From: Maria Tomalova <Maria.Tomalova@arun.gov.uk>
Sent: Wednesday, September 13, 2023 5:54 PM
To: Planning.Responses <Planning.Responses@arun.gov.uk>
Subject: FW: Y/105/19/PL and Y/106/19/L, Stakers Farm

From: Maria Tomalova
Sent: Thursday, June 18, 2020 12:59 PM
To: Ben Daines [REDACTED]
Subject: Y/105/19/PL and Y/106/19/L, Stakers Farm

Please see below Martyn's comments in red and mine in green.
(your email from 22nd May 2020)

Drawing Title
Proposed Plans - Barn 1

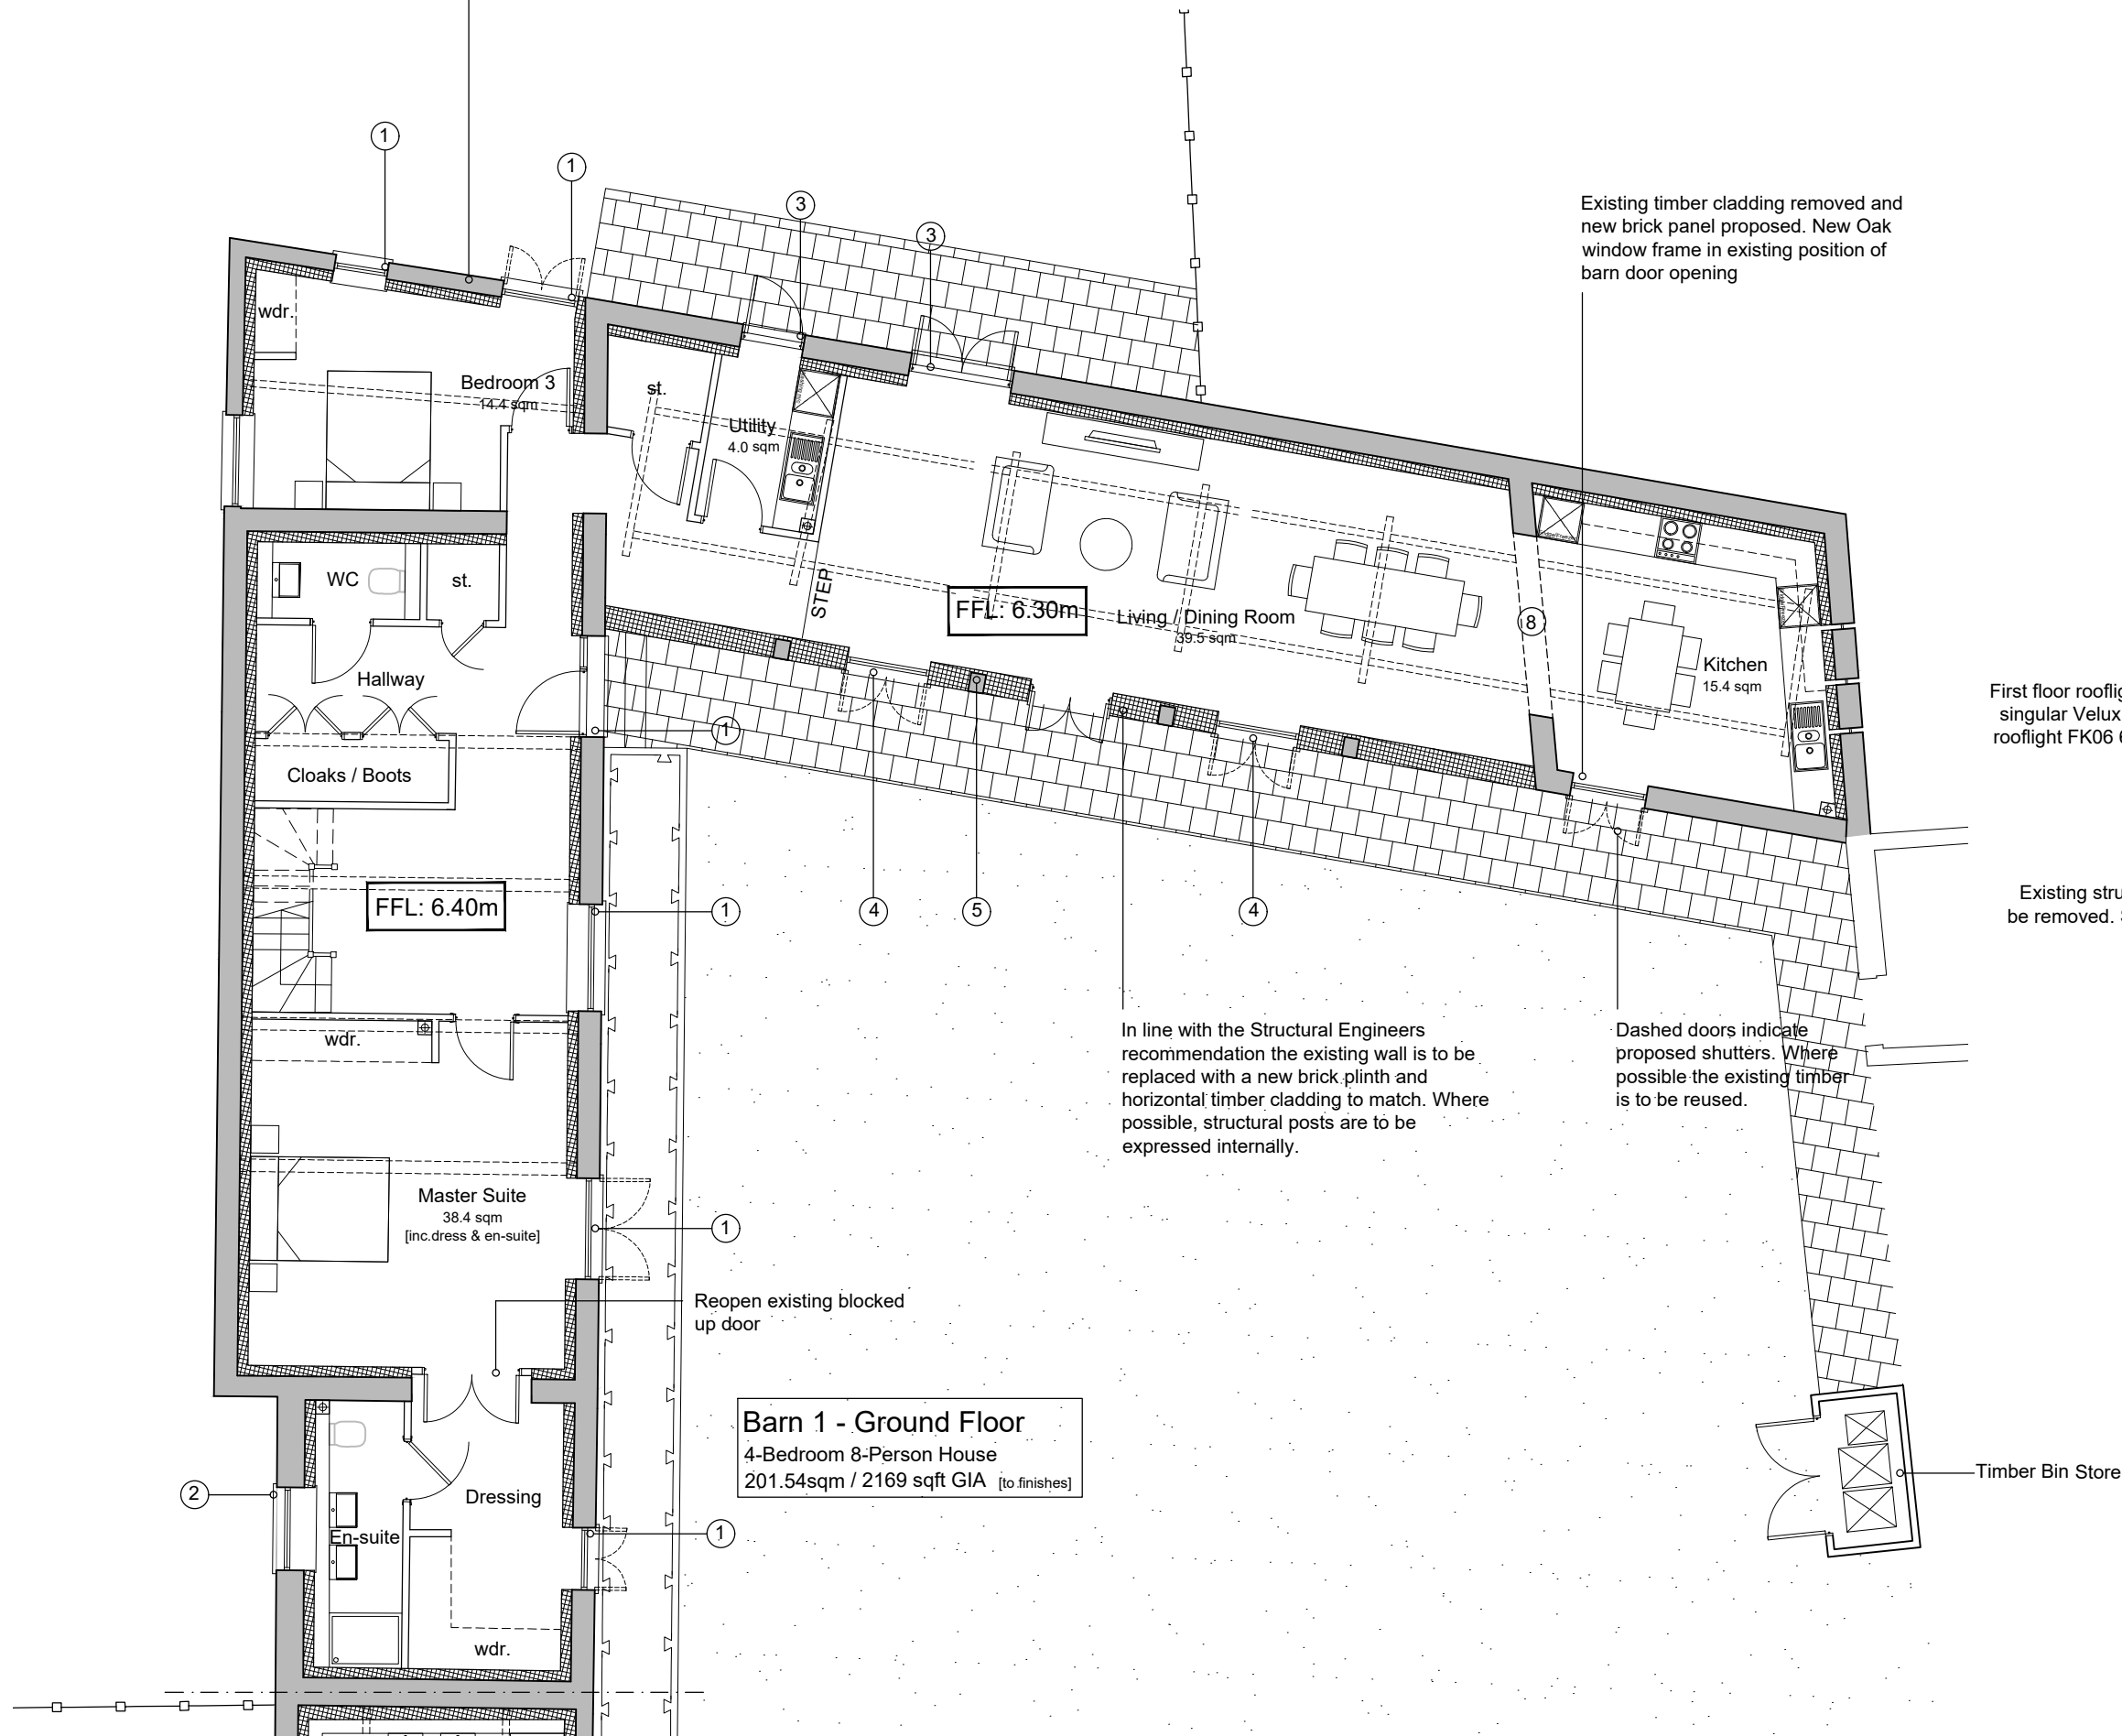
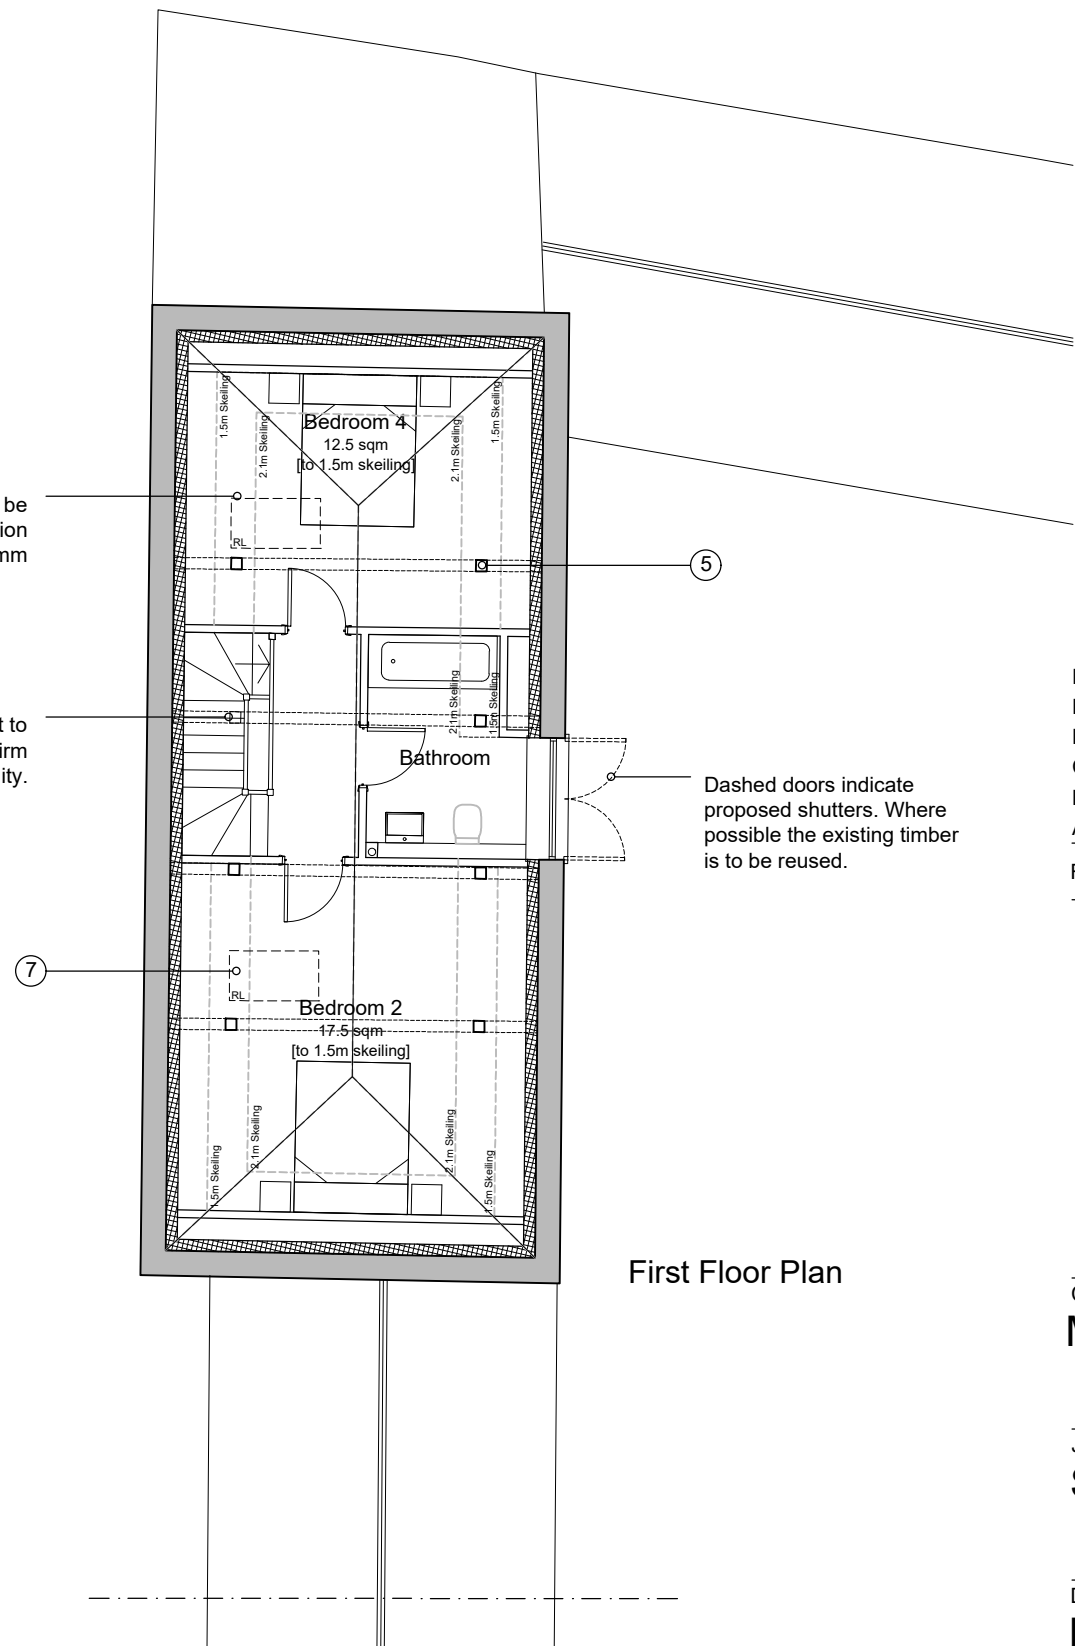
We will remove as many rooflights as possible from this barn. However, we cannot remove all the rooflights as we will need to provide light to the bedroom to make it a habitable space. A roof light will also be required to provide purge ventilation (Part F of Building Regs) otherwise a mechanical system would be needed. Under the Building Regulations we will also need to meet the Daylight and room brightness guidance set within British Standard BS 8206-2:2008 Lighting for Buildings. We will therefore seek to provide the very minimum amount of rooflights necessary to meet Building Regulations and seek to locate them on the least prominent part of the roof.

There should be as few rooflights as possible, and these should be placed on the rear elevations where they will not be visible. They should also be of conservation standard. No roof-lights on primary elevation. A casual glance should not reveal that the building has been converted. This means that unconventional arrangements of rooms are required. Roof structures comprise a dominant visual feature and should be left uninterrupted.

Drawing Title
Existing and Proposed Elevations - Barn 3

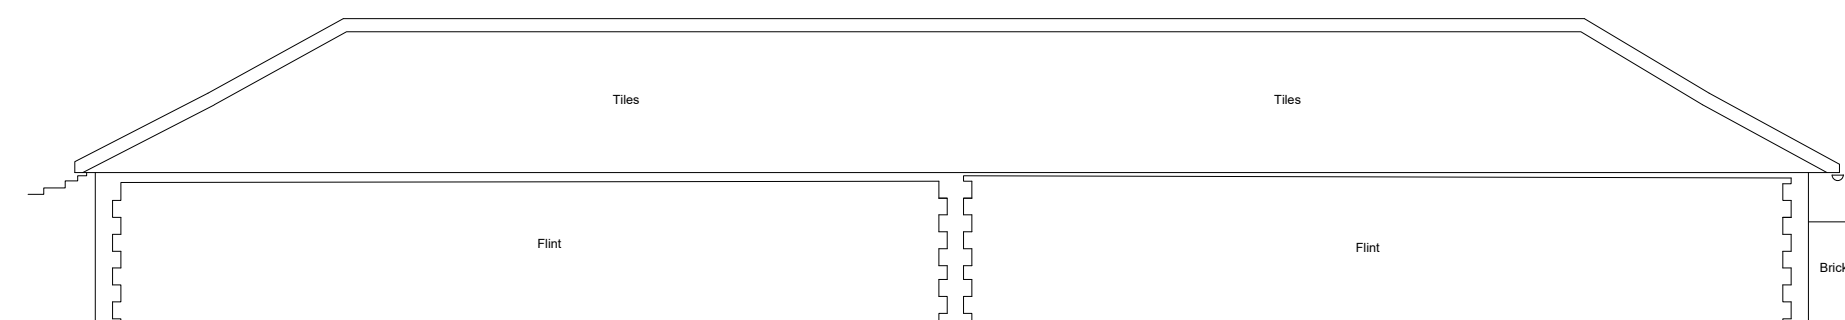
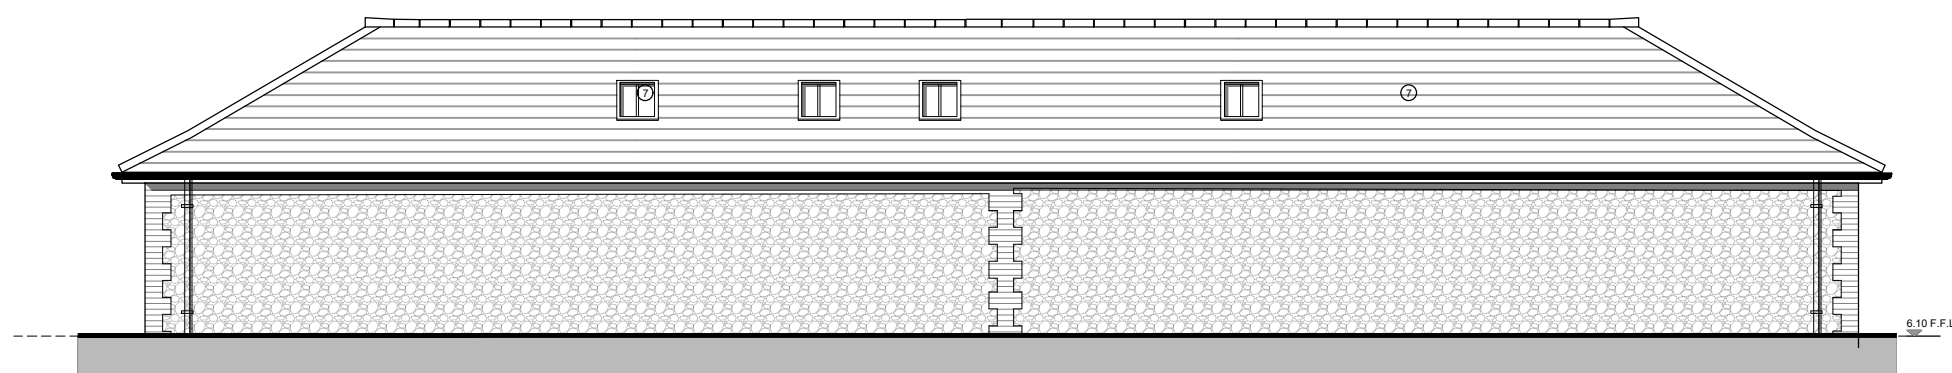
As I recall, no amendments to the drawings were required for this barn – previously there was a bi-folding door, but I believe this is to be removed?
